Client: S.W. Cole Engineering, Inc.**Project:** 93 Washington Avenue**SWCE Project #:** 18-0162**Date:** August 21, 2018**Subject:** Inspection of Field Welds and Bolted Connections**Report:** 001

As scheduled, a site visit was made on this date to inspect welded and bolted connections. We were advised that all work was completed.

Inspection was performed using drawings S1.0 and S1.1 (both rev. 2) as reference. Additionally, a call was placed to the EOR for clarification. Our actions and observations were as follows:

SECTION A-S1.1 3/4"=1'-0

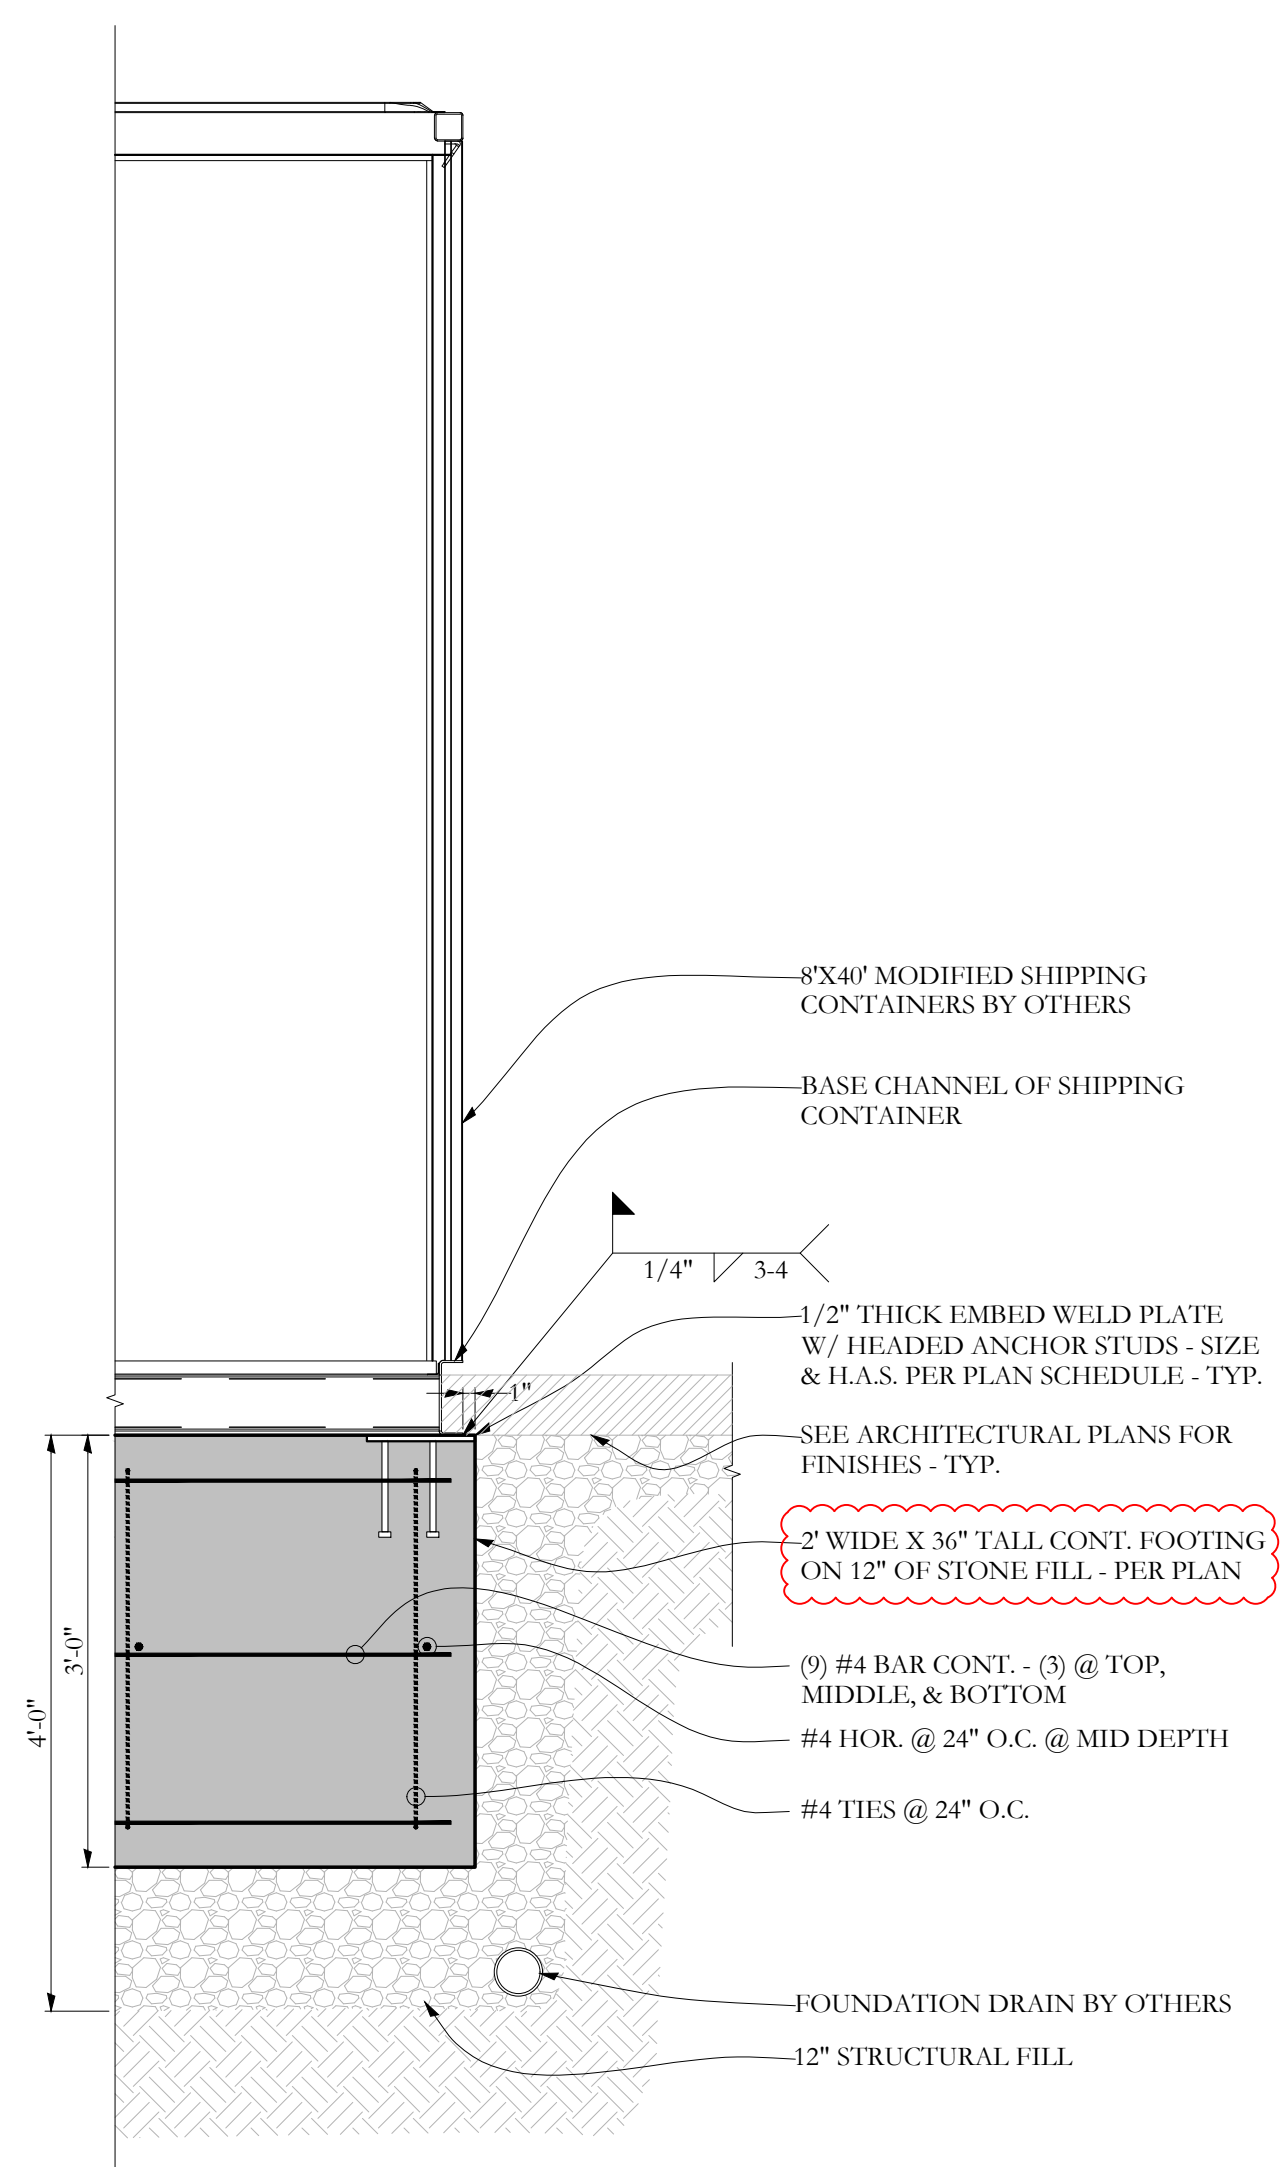
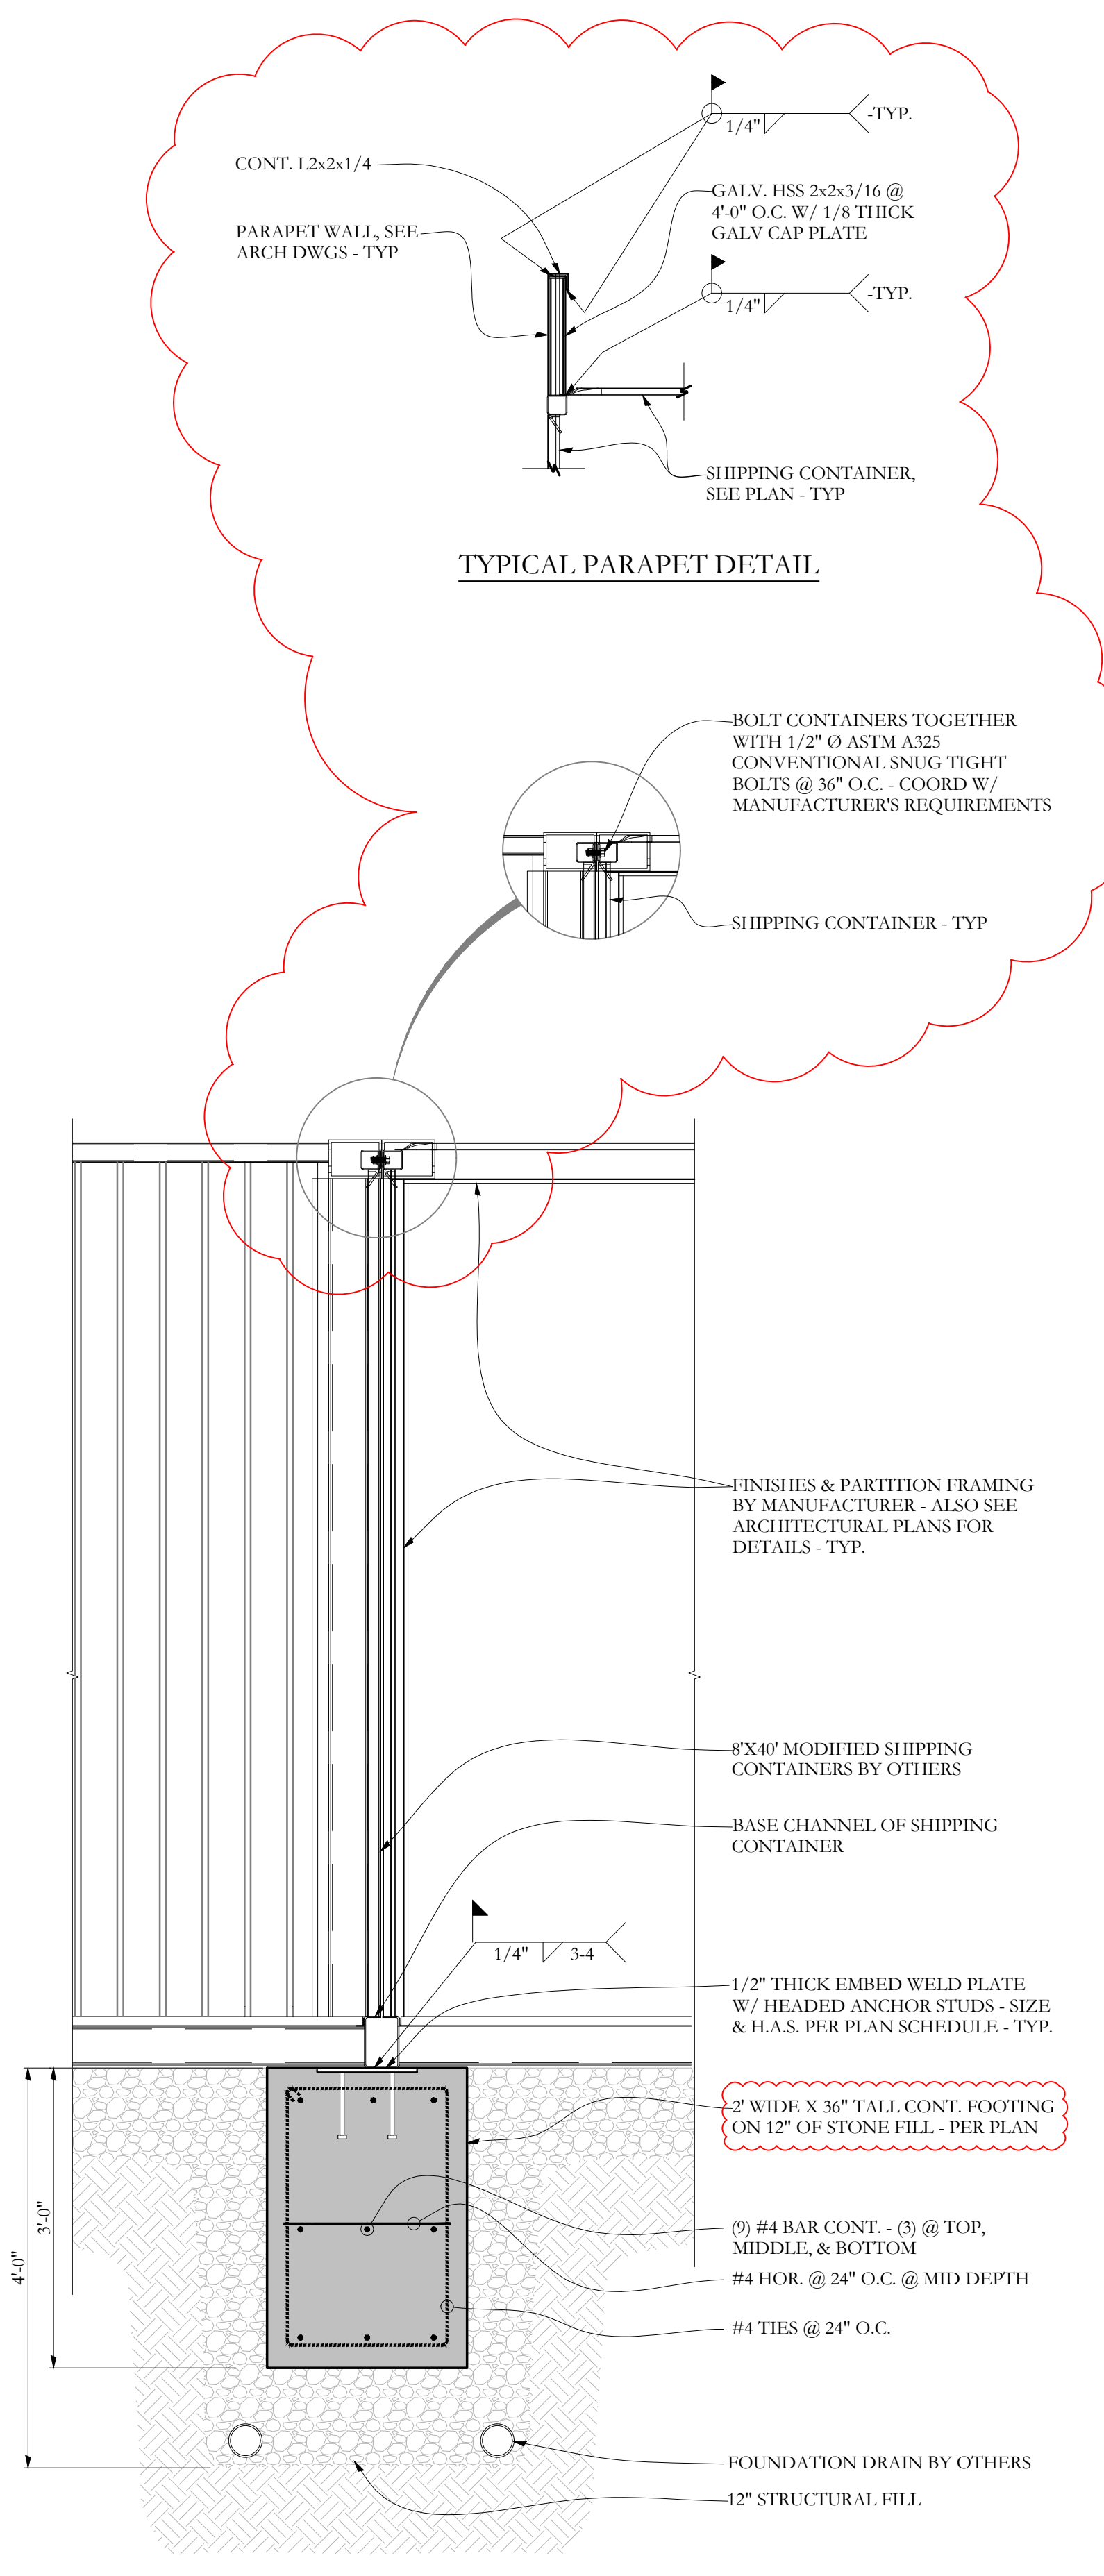
Welds were visually inspected for conformance to AWS D1.1 visual acceptance criteria and sections A/S1.1 and B/S1.1. Per the EOR 3" of weld attaching base to embed could be considered acceptable.

Welds were found to be acceptable per information provided with the following exceptions:

Weld missing on line 4

On line 1 the right support has approximately 2" of sound weld placed in the overhead position

Drawing S1.1 “Typical Parapet Detail” was used as reference. It was observed that all connections were bolted rather than welded. The following is noted:

At corner connections on lines A and G it appears that bolts may thread into studs from parapet.

At the rear connections it appeared that threaded studs were welded to the containers. However the amount of weld used appears inadequate. It appears that nuts were then used as couplers and a section of threaded rod and nut installed anchoring the parapet to threaded rod on the container. Excessively large holes were cut in the parapet base causing the connection to be ineffective. Also, full nut engagement was not always obtained.

It is recommended that the EOR visit the site and determine what corrective action may be required.

Welding of the parapet to the container may be difficult at some locations as some of the surfaces to be welded are flush.
